Subject: RE: Yapton Metal Company - refs Y/42/19/DOC and Y/61/19/PL

SURFACE WATER
DRAINAGE STRATEGY

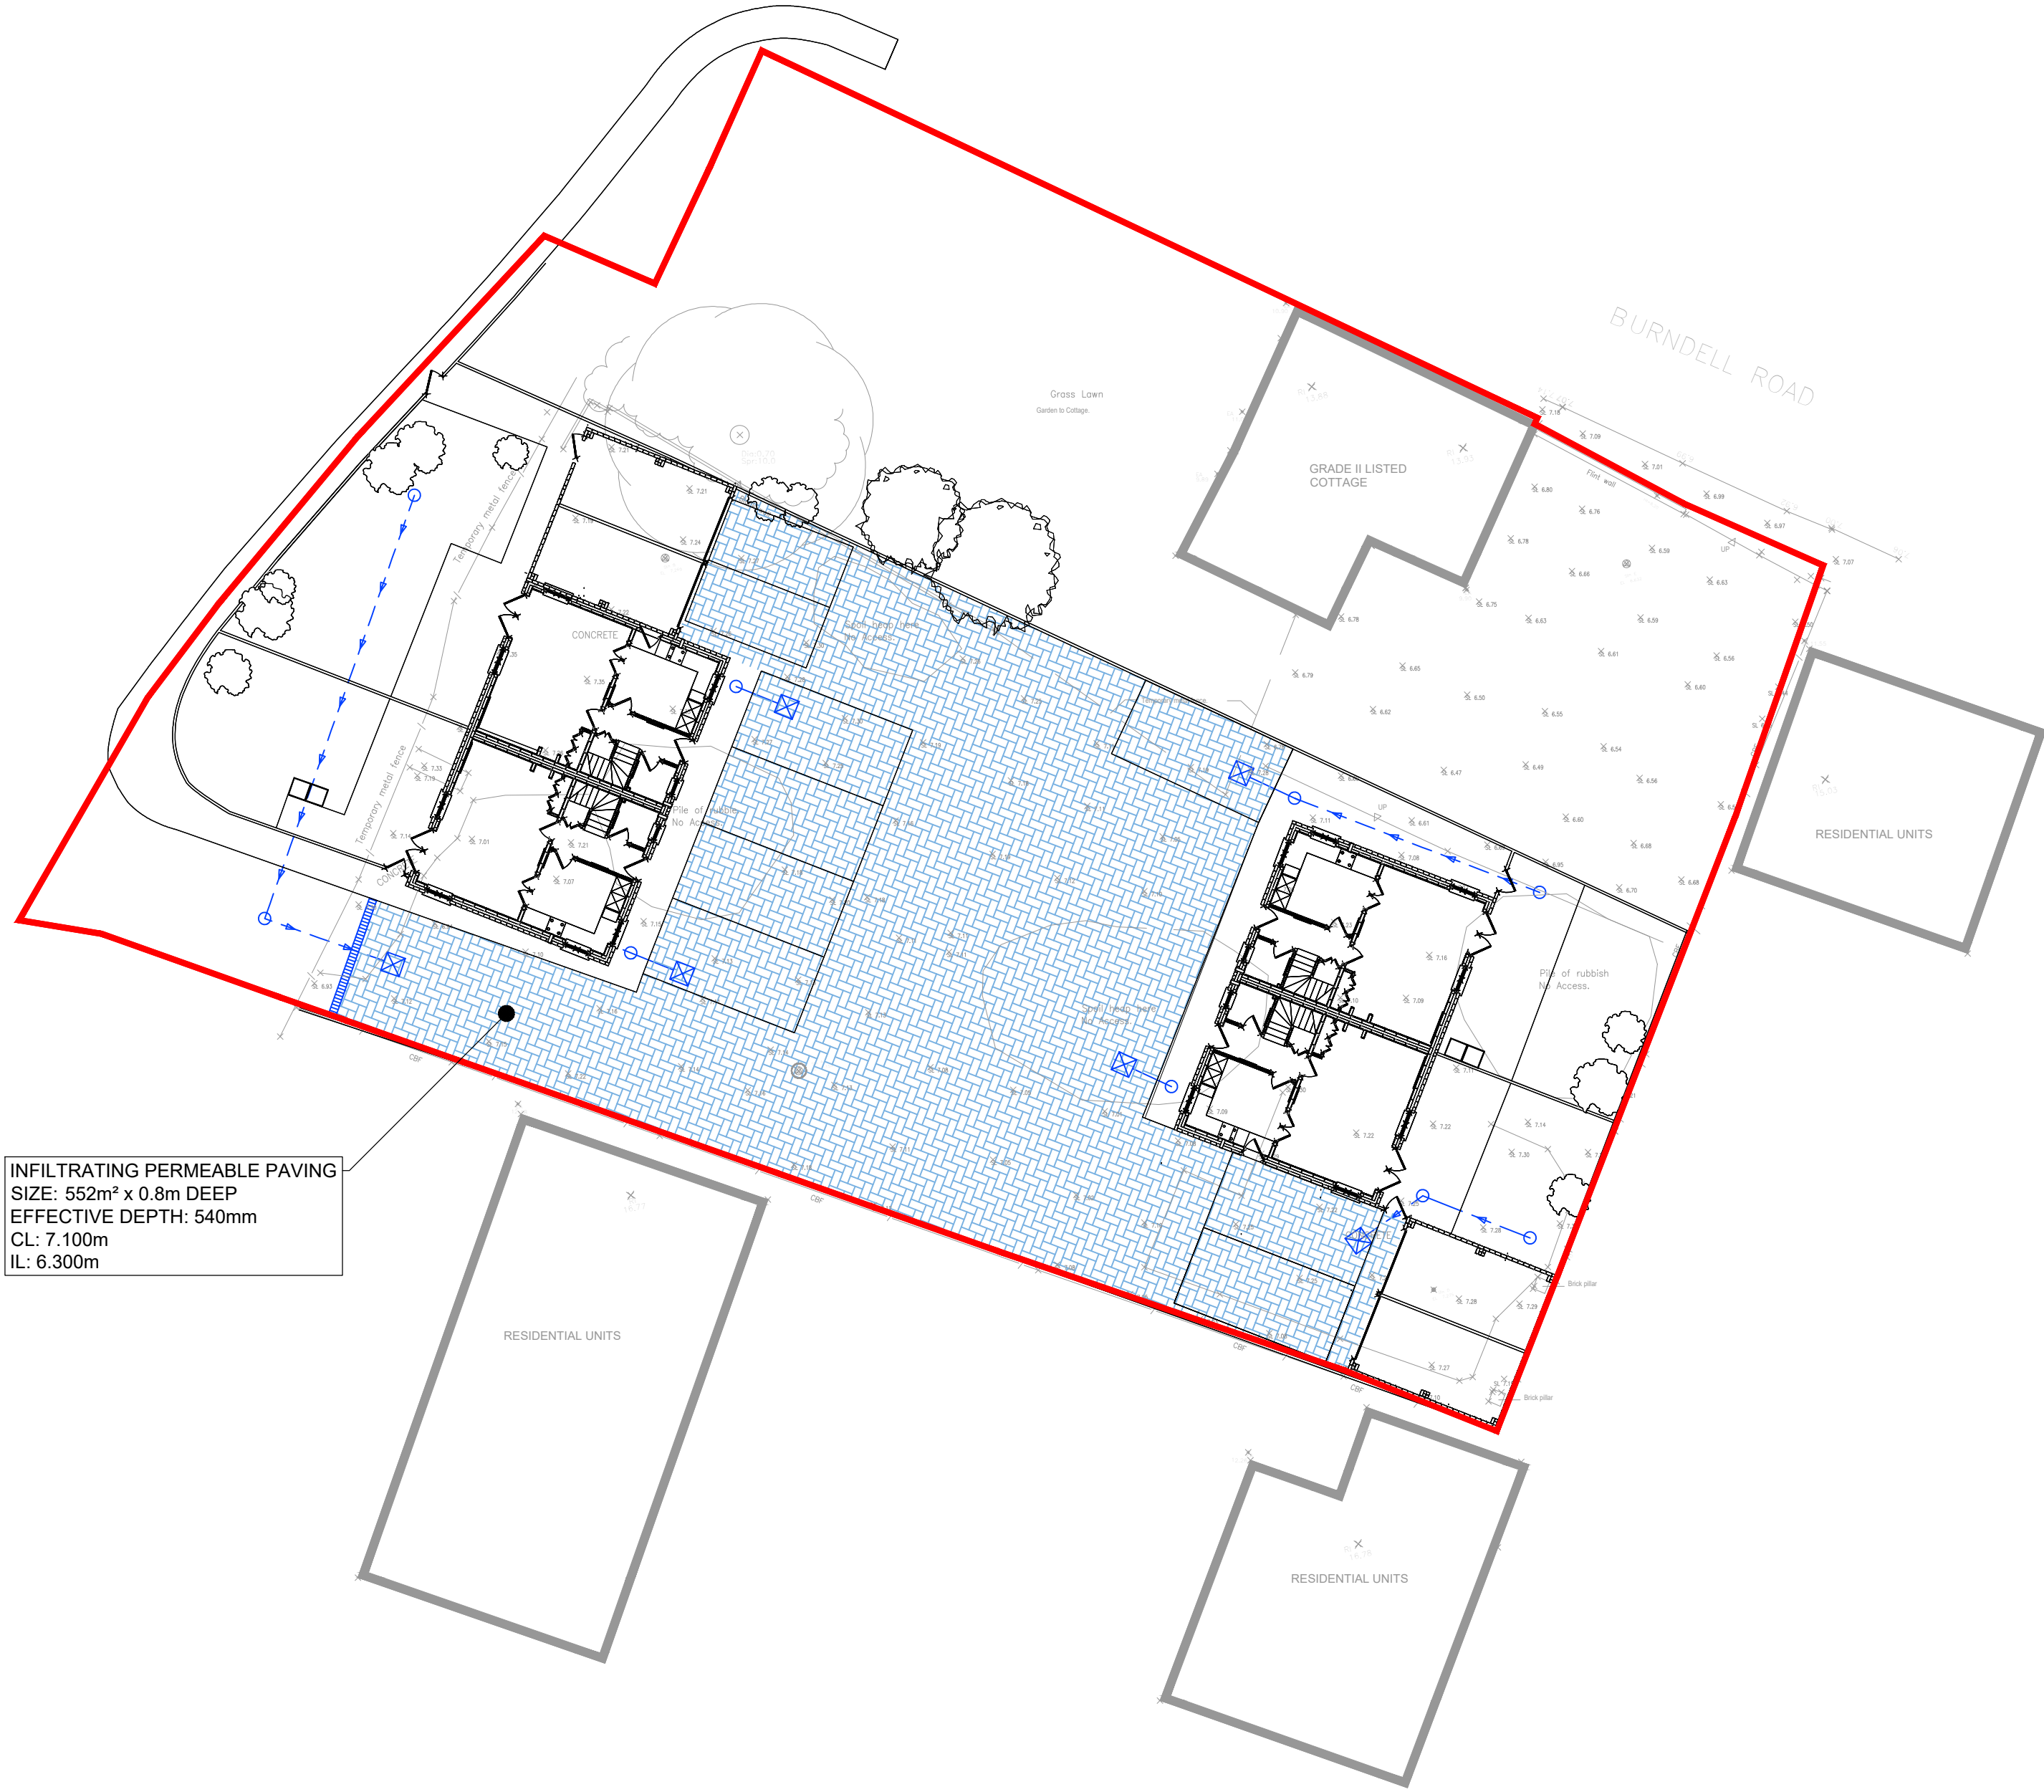
Further winter infiltration testing will be required, at the depth of your proposed permeable paving, as ground conditions in July would be expected to be more permeable. Whilst I am confident you will be able to find an infiltrating solution within the confines of the site I am unable to approve discharge of conditions until you can prove your design meets our requirements with both calculations and testing.
